**WEST SUSSEX COUNTY COUNCIL
STRATEGIC PLANNING CONSULTATION**

SUBJECT: FP/19/17/DOC - Application for approval of details reserved by condition imposed under FP/102/16/PL relating to conditions 3-foul water drainage, 4-surface water drainage, 5-as-built drawings of implemented scheme, 6-SuDS system & 8- Construction Environment Management Plan (CEMP).

Site 6 Phase 4 & 5 Land North of Felpham, Guillvers Mead, Felpham

Drawing Title:
PHASE 4&5 RE-PLAN.
EXTERNAL WORKS LAYOUT.
SHEET 14 of 17.

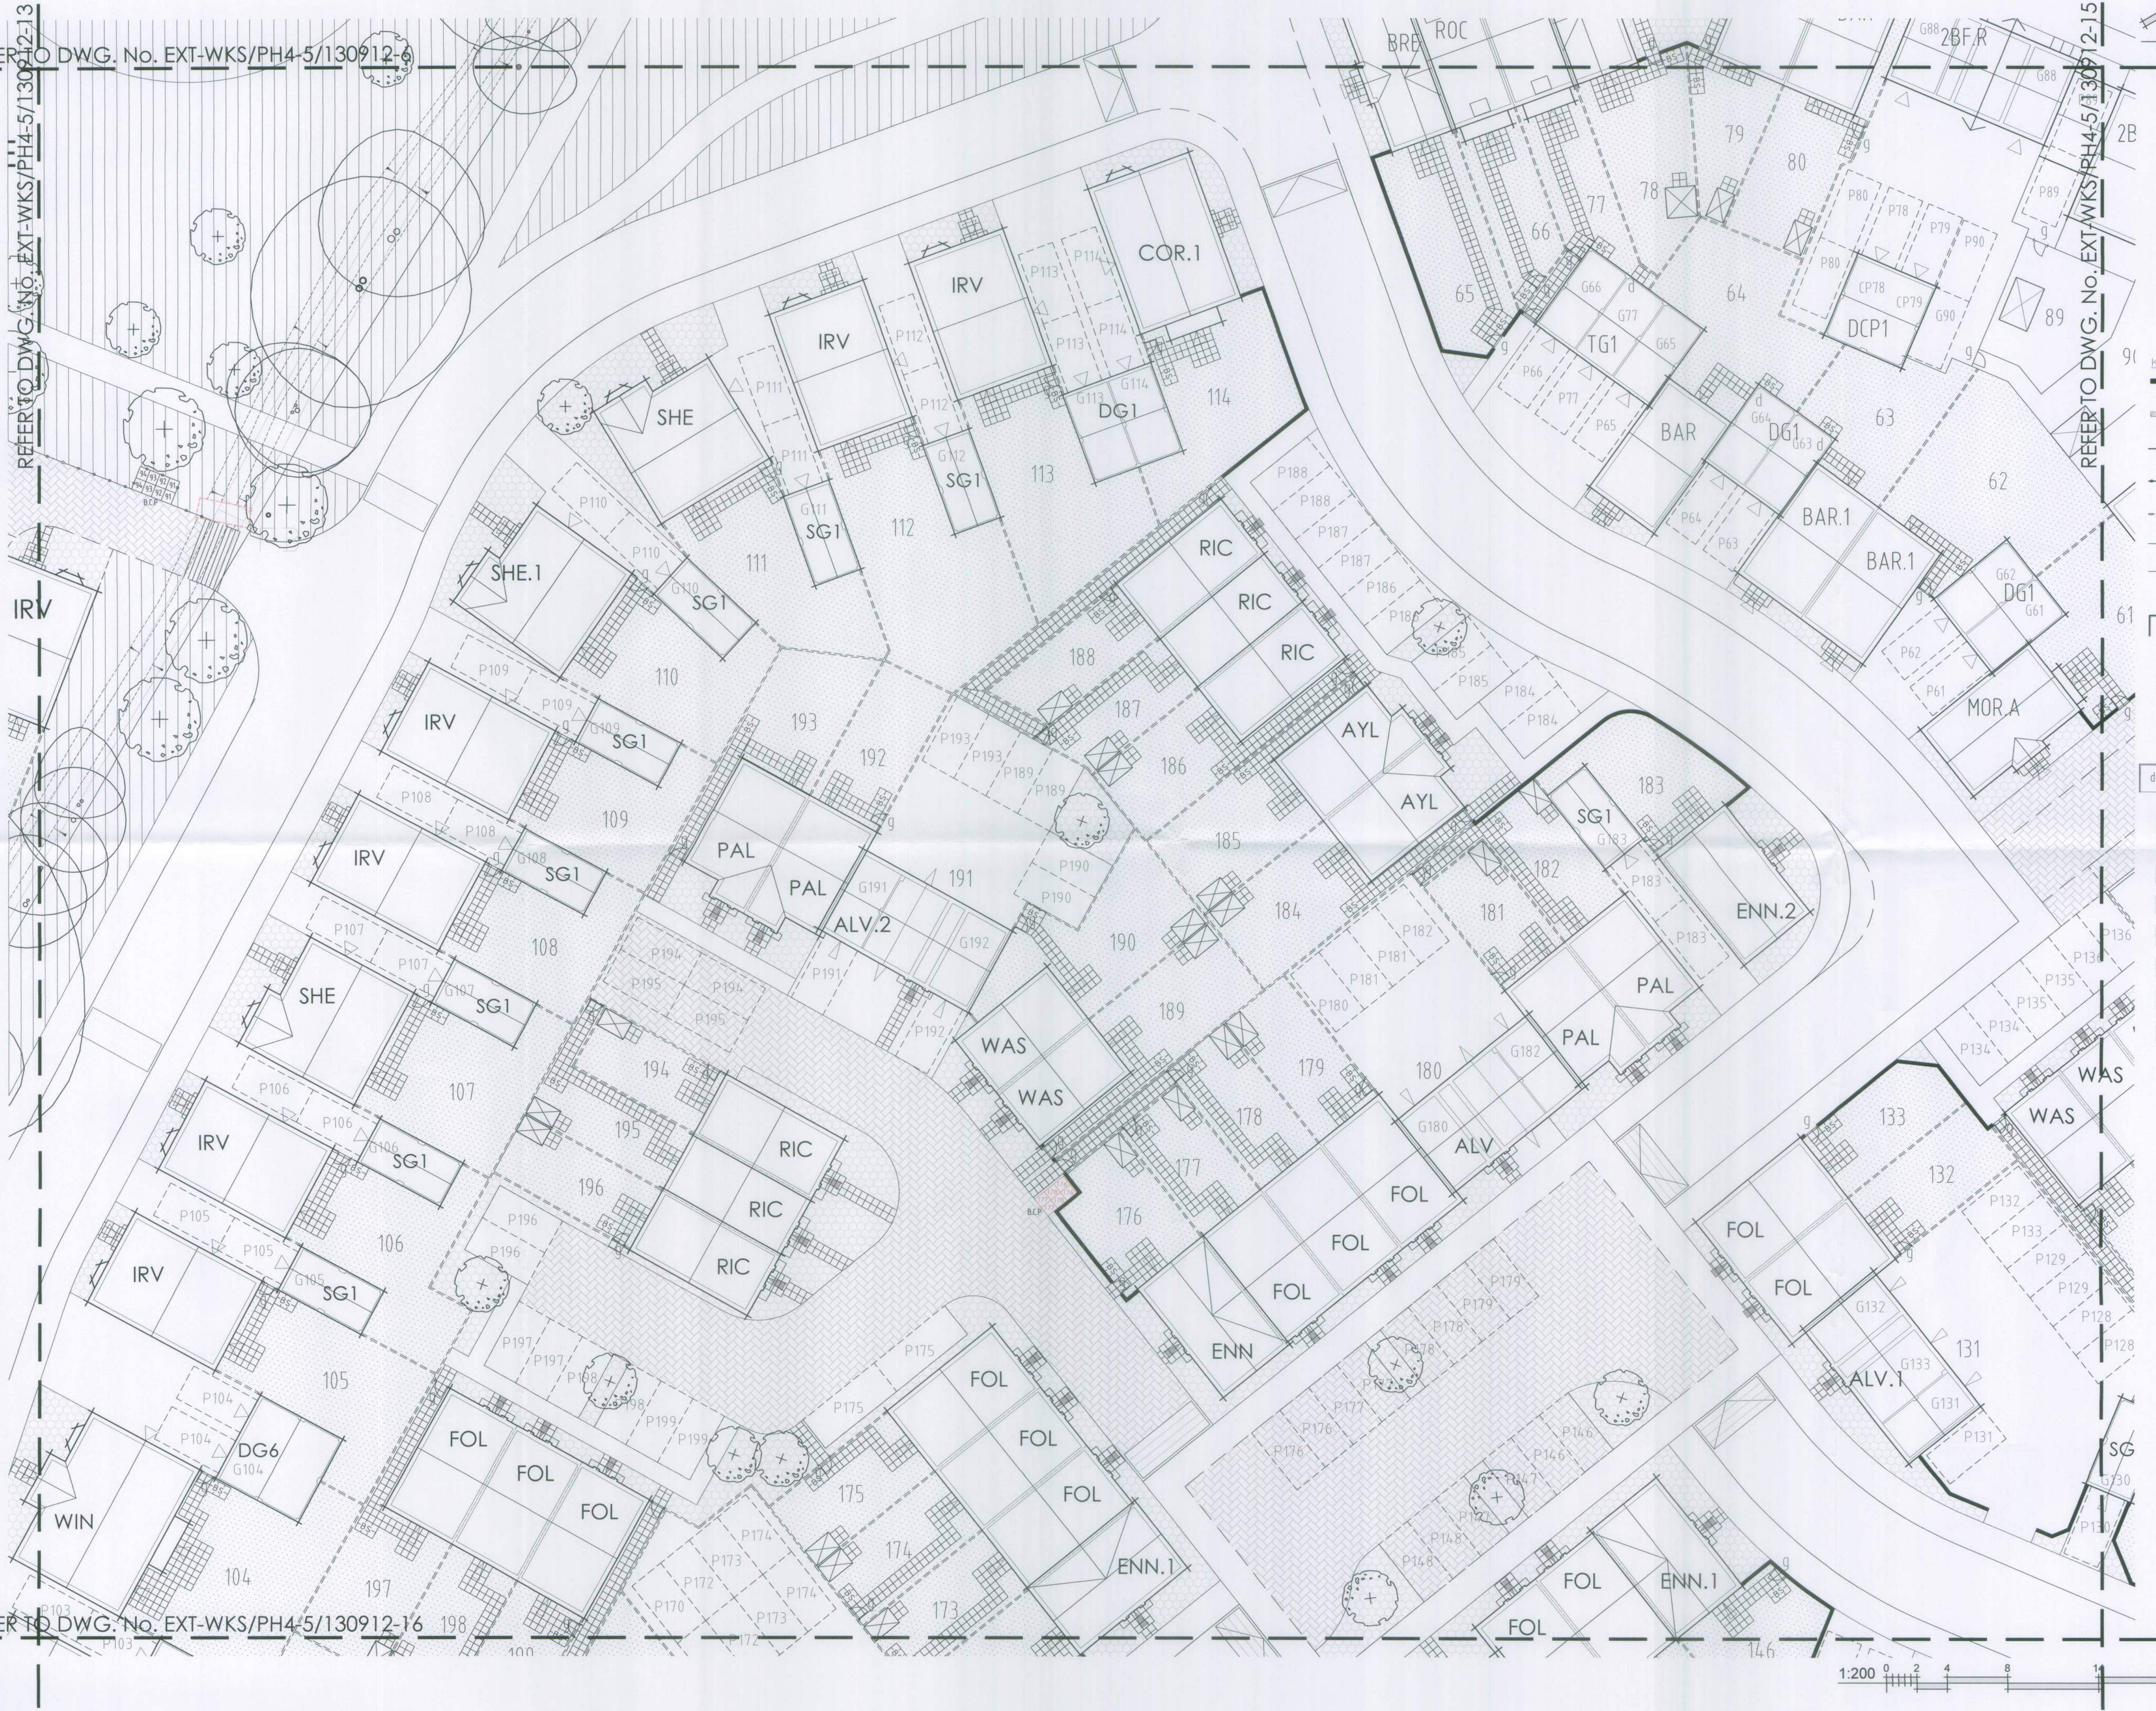
There does not appear to be a coherent vehicle route or any information as to why some sections of road are to be tarmacadam and some to be block work. Can the applicant provide 1 plan showing the traffic route through phases 4&5 and which sections are proposed for public highway and which sections are to remain private. Not recommended for discharge at this stage.
